Parks and Wildlife

August 27, 2018

Re: Gardens at North Carefree PUDSP

DEVELOPMENT PLAN

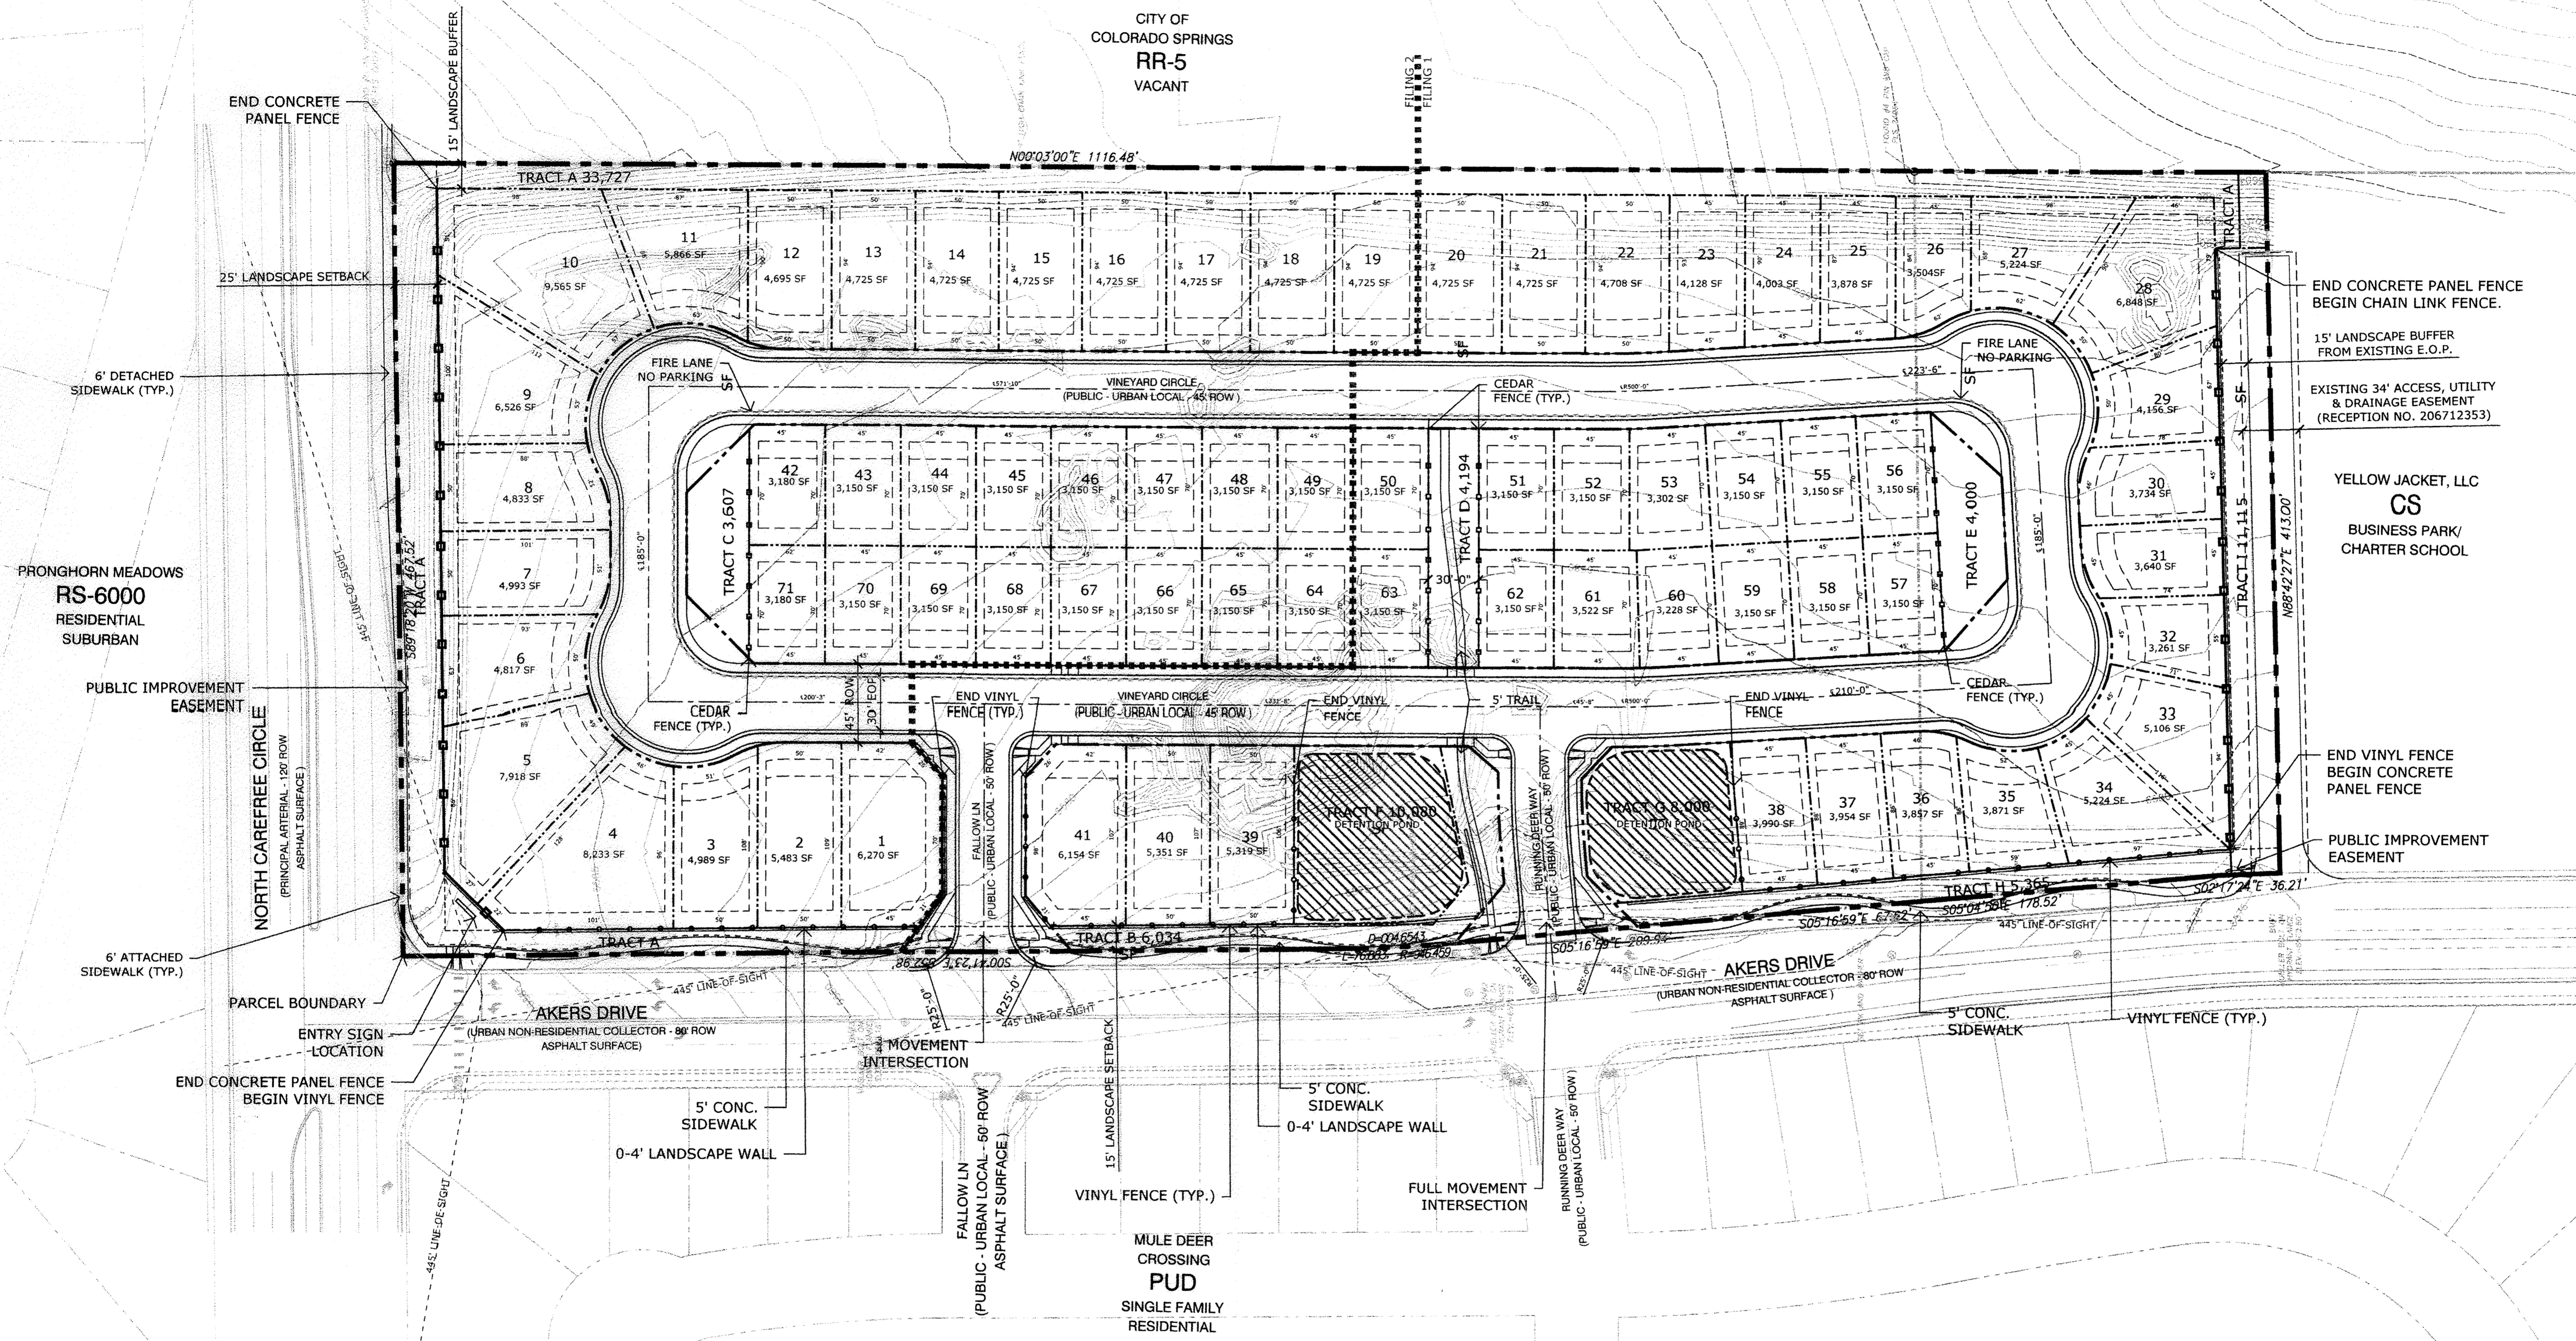
In the plans it was written that a section of chain-link fence with barbed wire on the top would be used to connect to the existing fence that is already on the east side of the development. Fences can cause many problems for wildlife, including death, entanglements, and barriers to movements. CPW recommends the developers consult our publication *Hanophy, Wendy* "Fencing with Wildlife in mind." *CPW.state.co.us. 2009* when considering the design of fences within the development. The publication is available on our website and we would be happy to provide a link to the PDF specifically. The use of privacy fencing, chain link fencing, and other exclusionary fencing should be at least 6 feet high and should be restricted to the immediate area surrounding the buildings or within the designated building envelope and should not be used as a method to designate boundaries of larger lot sizes (> 1 acre). Fencing outside the immediate building envelope or area surrounding the buildings on larger lots within the known range of elk, deer and pronghorn should be a maximum top height of 42" with at least 12" spacing between the top two wires or rails and a bottom wire or rail at least 16" above the ground to allow passage of juvenile animals and pronghorn antelope. It is also recommended that the top and bottom wires be a twisted barbless type or smooth wire or rail construction. It should be noted that it is very distressing to find wildlife in or ensnared on fences.

These are general recommendations for fences, however for the section planned to be connected to the already existing chain-link fence, it would be good to eliminate gaps

between the new section and existing section, and to eliminate the barbed wire at the top of the new section to eliminate deer entanglements.
